Application for a non-material amendment following a grant of planning permission.

Proposed redevelopment of the existing house including a single storey extension to the side and first floor extensions to the front and change of external materials.

Reference number:	<input type="text" value="03/2020/0304"/>
Date of decision	<input type="text" value="26/06/2020"/>

PROPOSED FIRST FLOOR PLAN

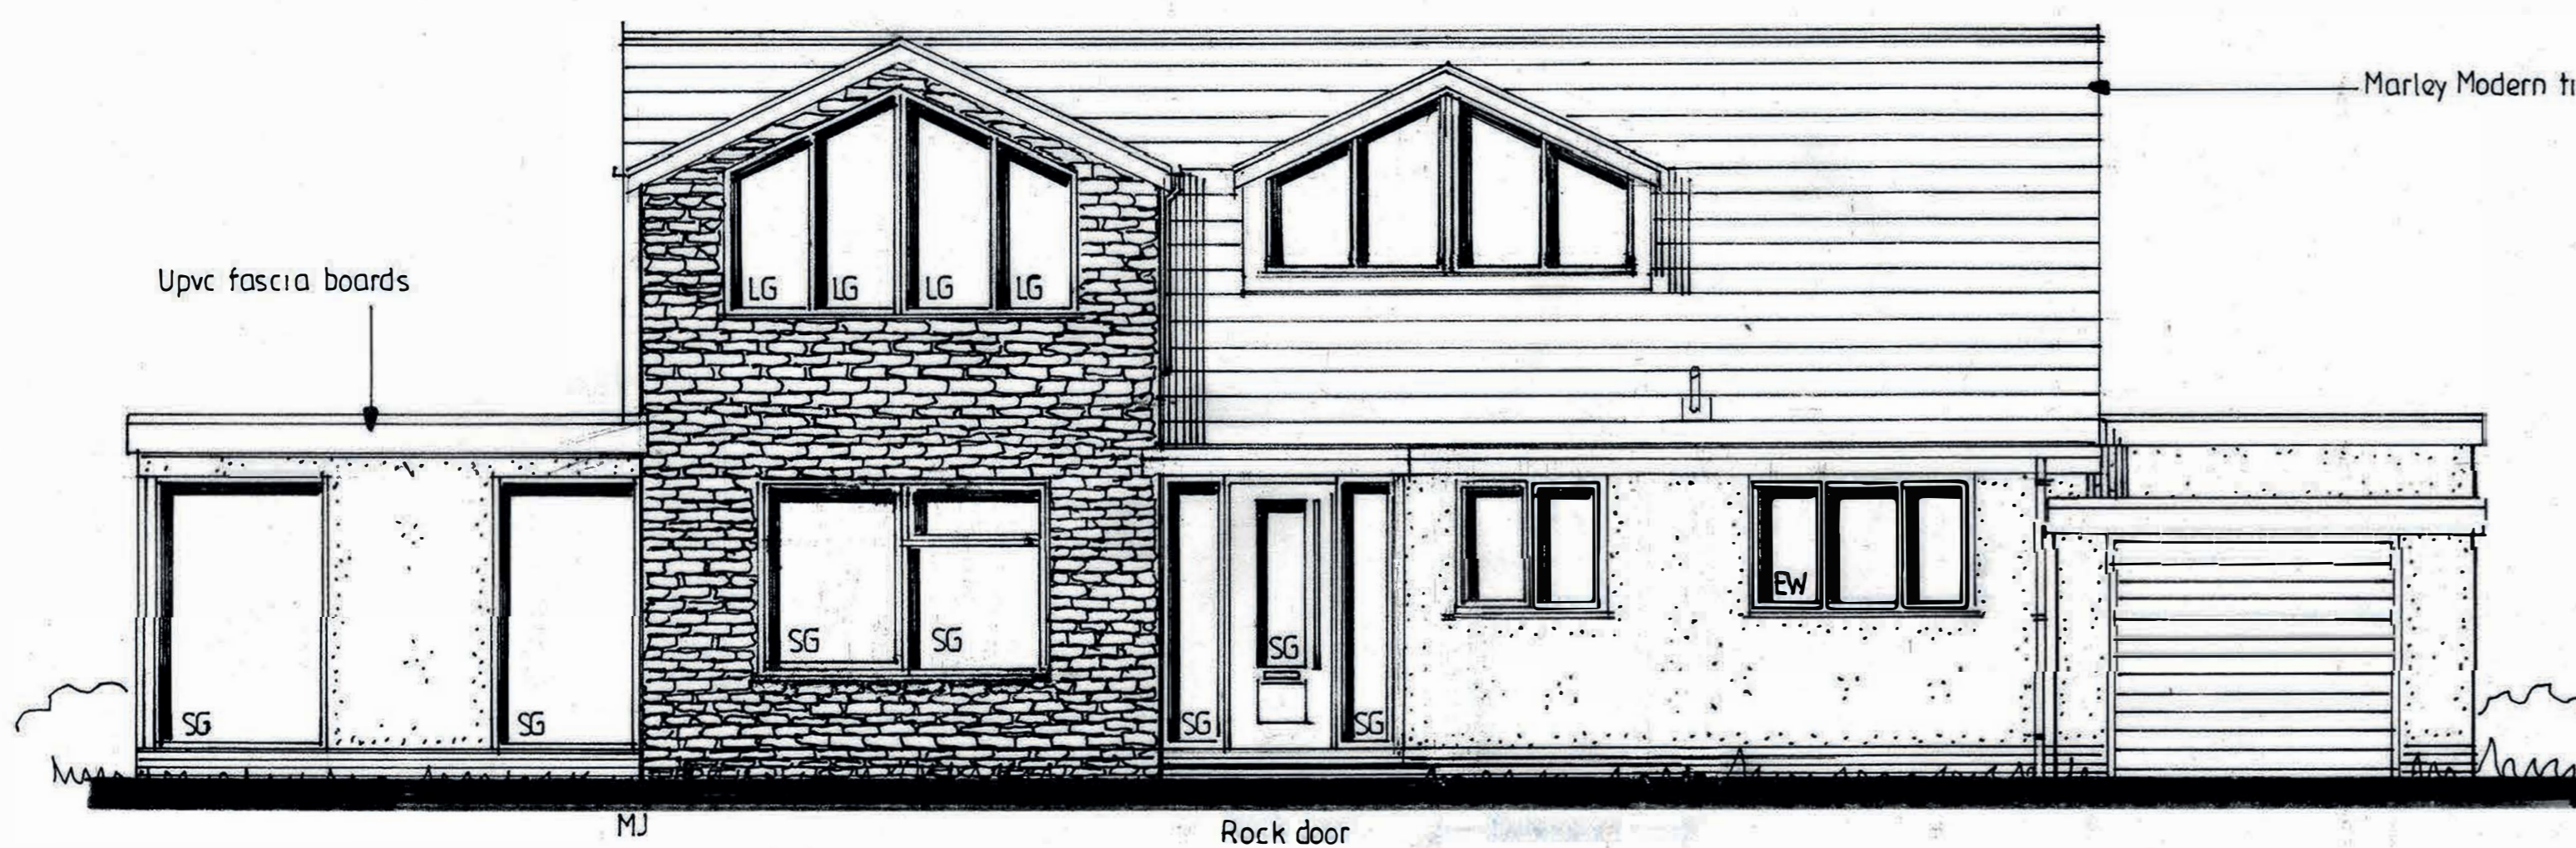
It is proposed to delete the French doors at first floor level (shown dotted on plan) from the gable end facing George Lane. Install a new rectangular window with cill height level with front window. The new window is in the same location as the original bedroom window. It is also proposed to delete the small window at first floor level on opposite side of the new two-storey front extension facing number 5 Tennyson Avenue (shown dotted on plan)

PROPOSED SIDE ELEVATION

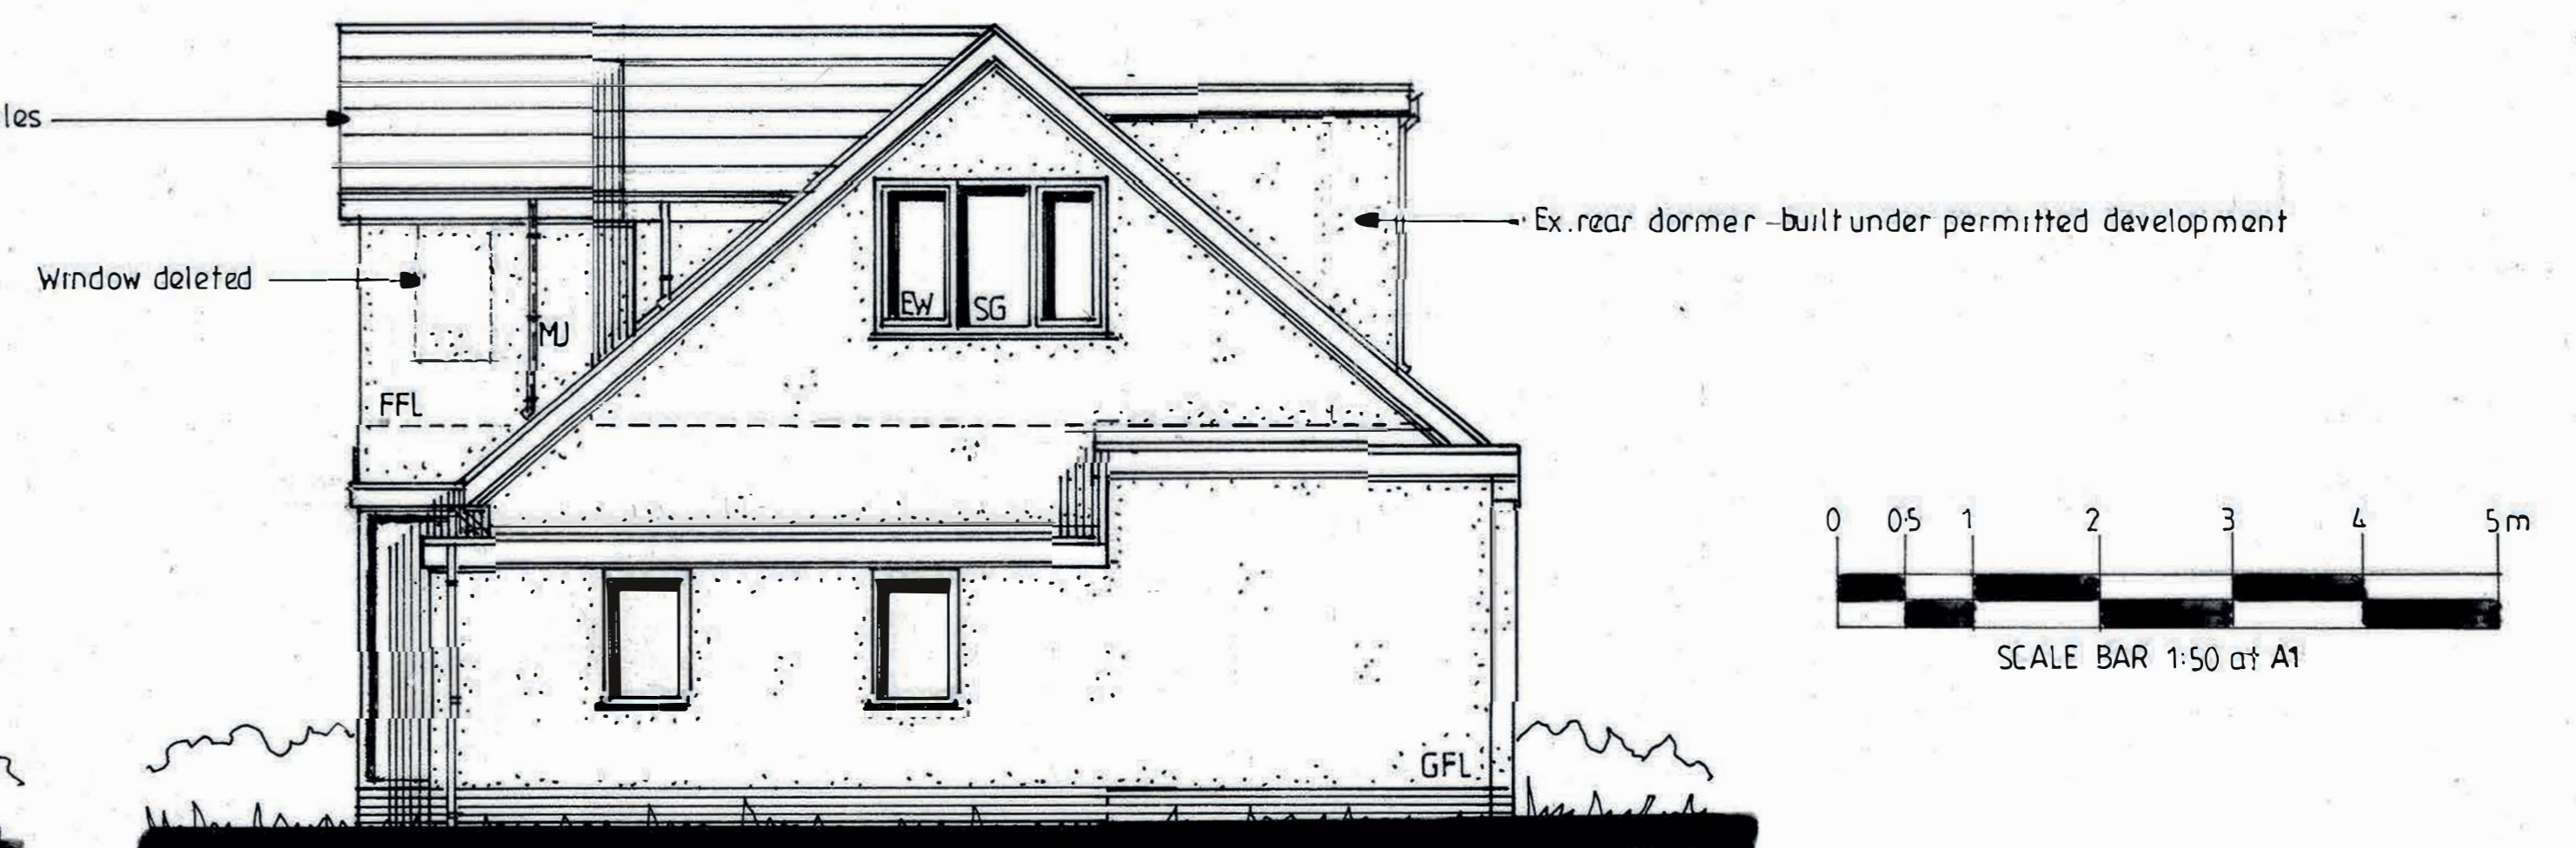
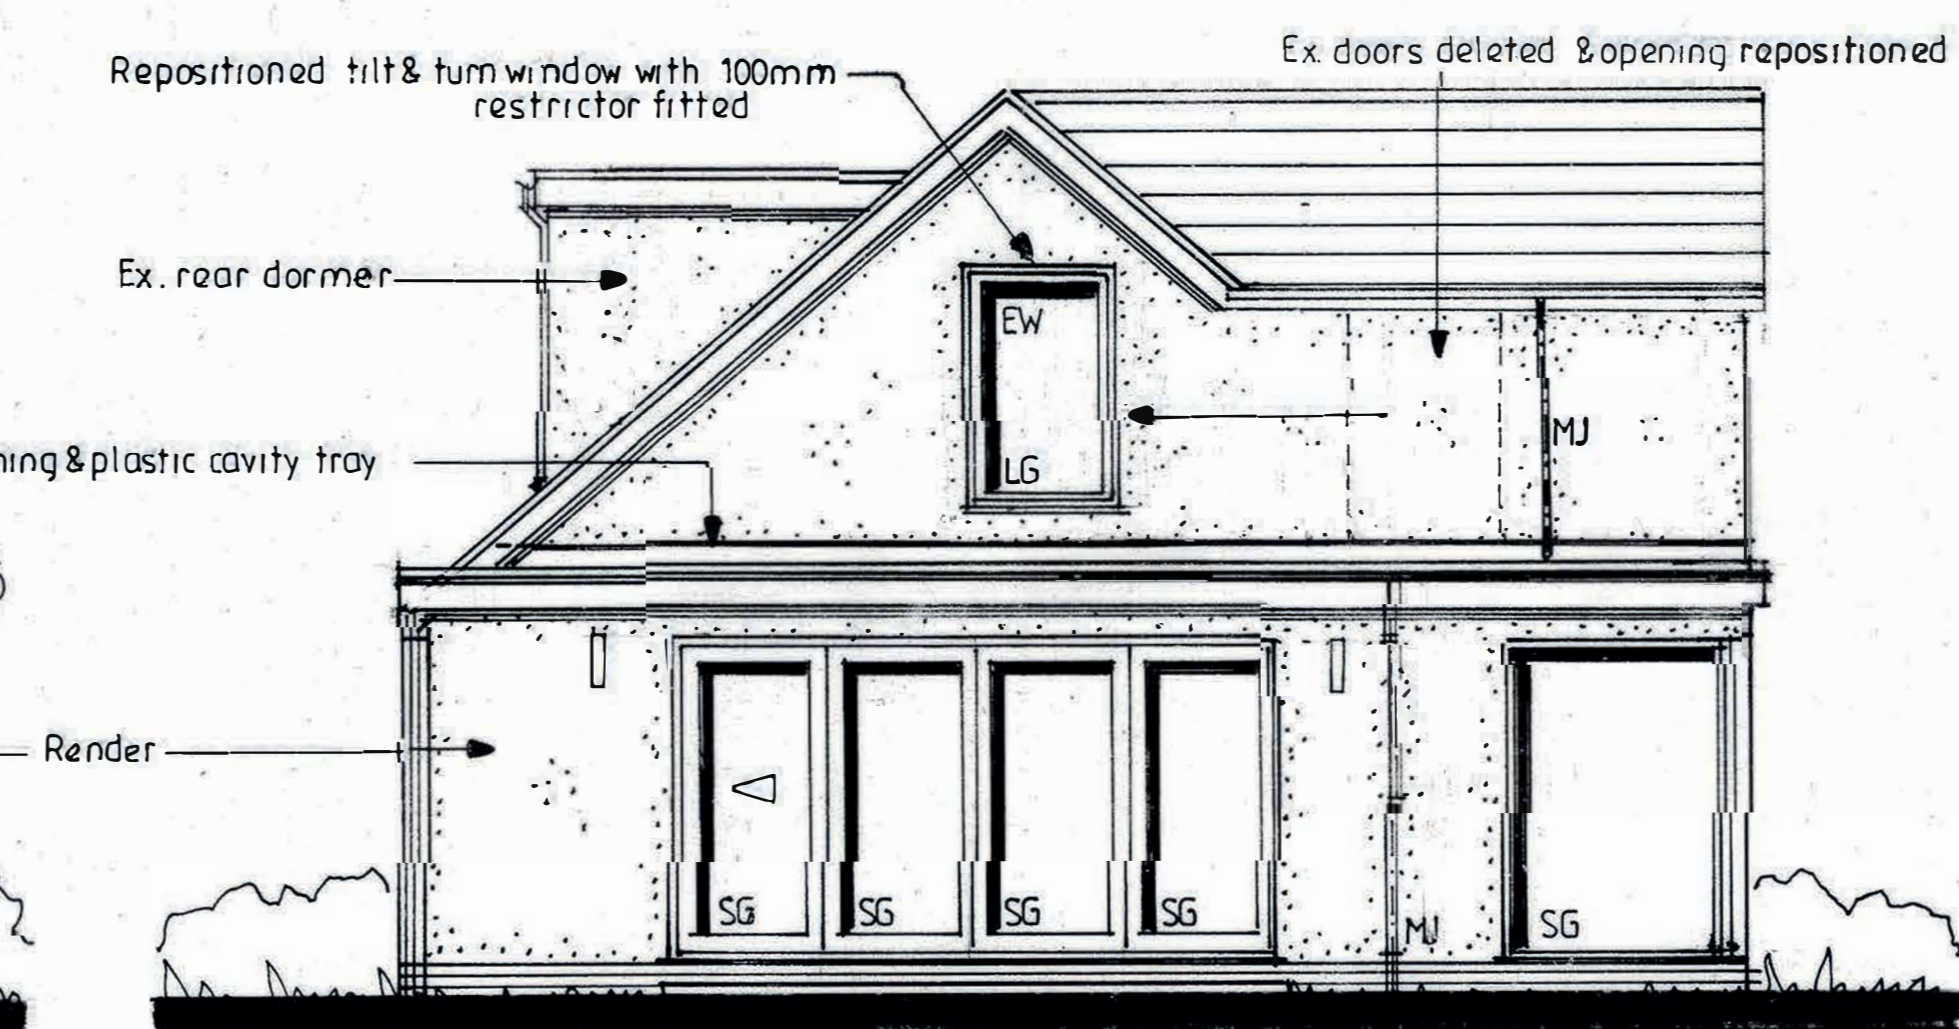
The French doors are being removed because the original balcony indicated on an earlier plan was deleted to comply with amendments requested by the planning department. The doors serve no purpose any longer and the top of the doors are below head height when stood in the bedroom and offer no view. A new window is to be provided back in the middle of the gable (in the same location as the original bedroom window) as no access is required to the roof and to provide additional height. The small window on the opposite side of Bedroom 1 has been deleted as it spoils the layout of the new bedroom furniture, it was also sited within 665mm of the front corner which is the minimum distance required by the building regulations and was again too low to look out of. The removal of the window has provided a reduction in the overall glazed area which was required to meet the energy conservation requirements of the building regulations.
